Application number: 2023/91207	
What is the application for?:	Erection of extensions and alterations
Address of the site or building:	73, Bunkers Lane, Staincliffe, Batley, WF17 7QT
Postcode:	WF17 7QT

Type of comment: An objection	
Do you wish your comments to be published on the website anonymously?	Yes

PROPOSED FRONT

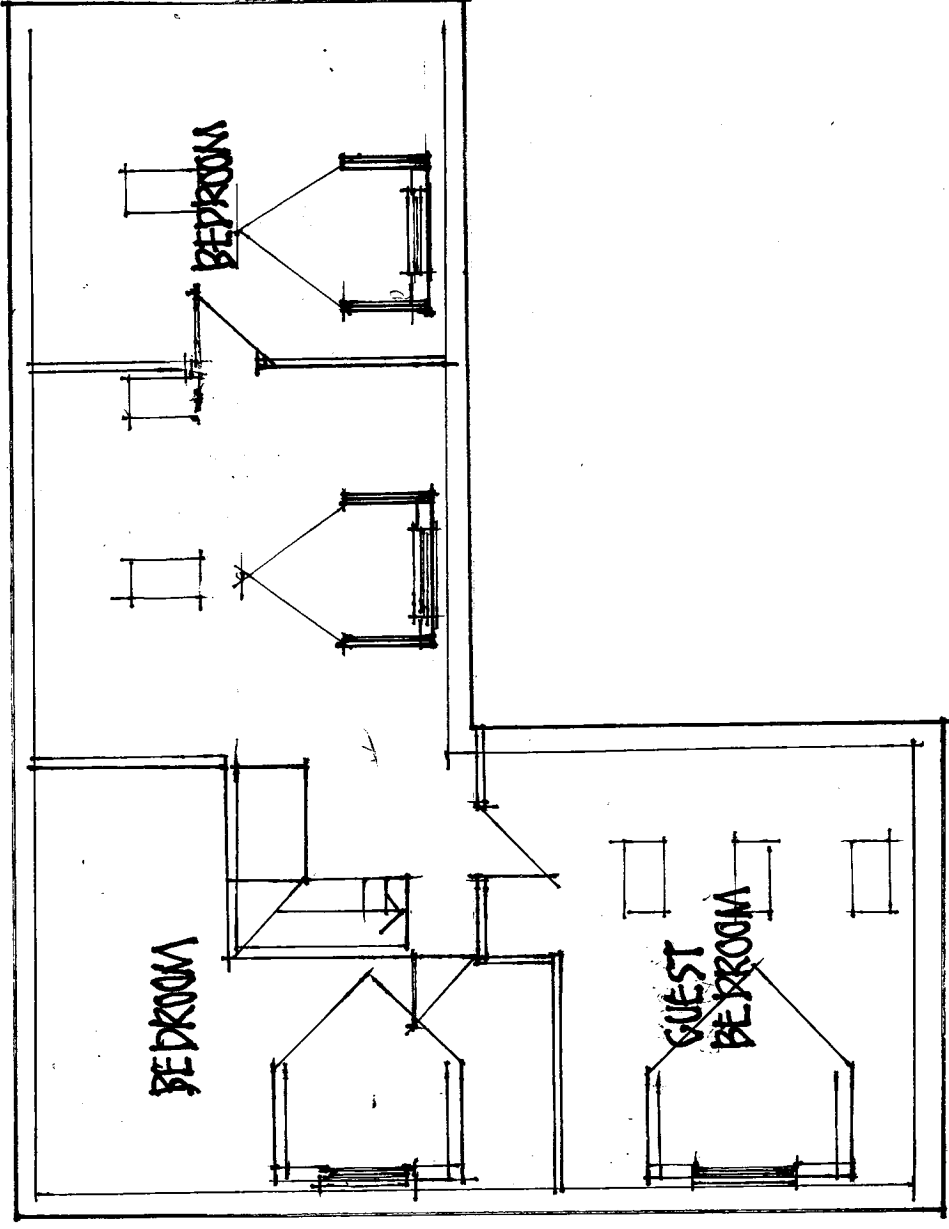
- 3) The "Proposed elevation to drive" shows the addition of two dormers and a 2 storey addition to the existing building. The dormers are positioned directly looking into the kitchen, living area and gardens of 73A Bunkers Lane and Deighton Holme leading to detrimental loss of privacy for both properties.

73 BUNKERS LANE, BATLEY

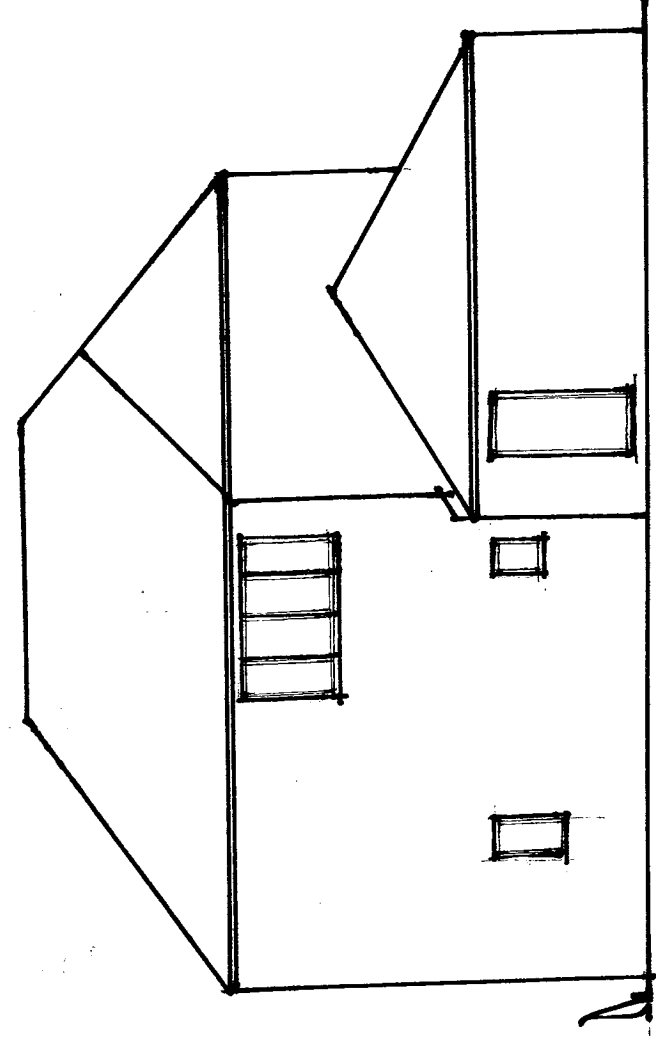
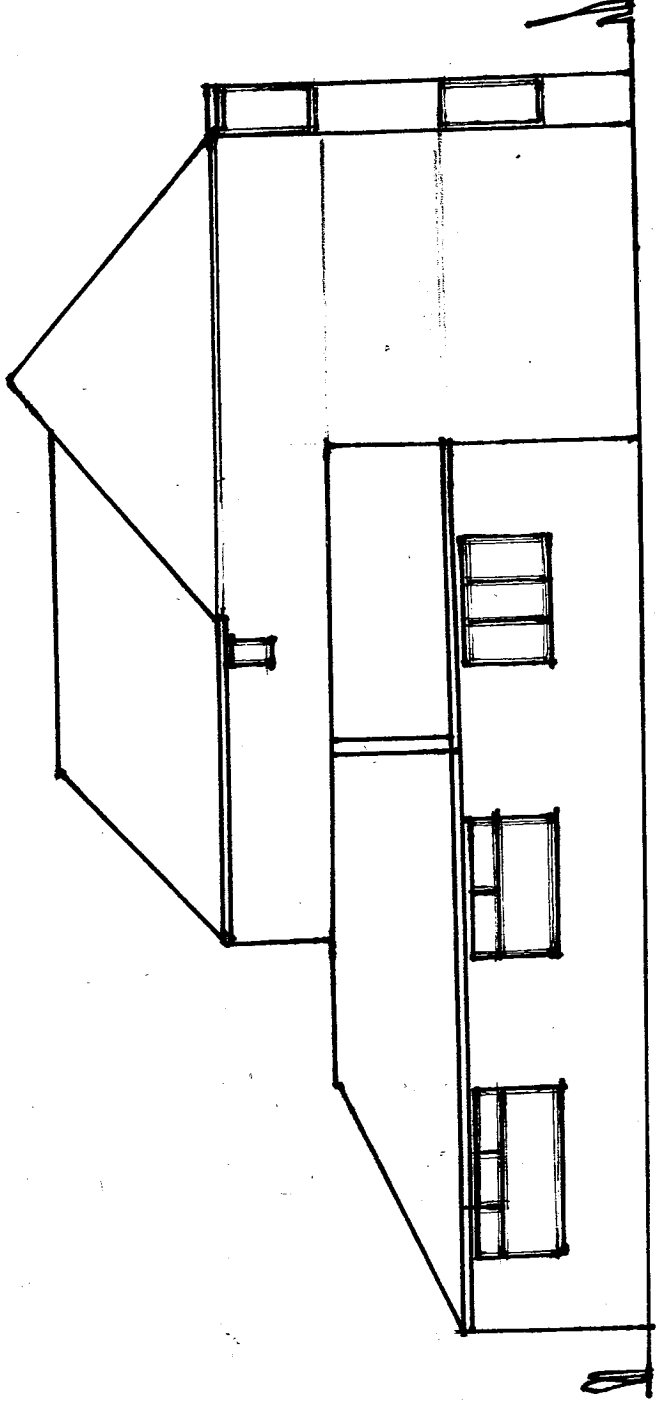
- 1) The proposed plans show a significant extension to the existing property including raising the existing roof on the North and West sides according to the submitted plans. Parts of the existing elevations on this side are one storey. Raising this to 3 storeys, as well as increasing the width of the property would cause significant overbearing on surrounding properties such as 73A Bunkers Lane and 71 Bunkers Lane.
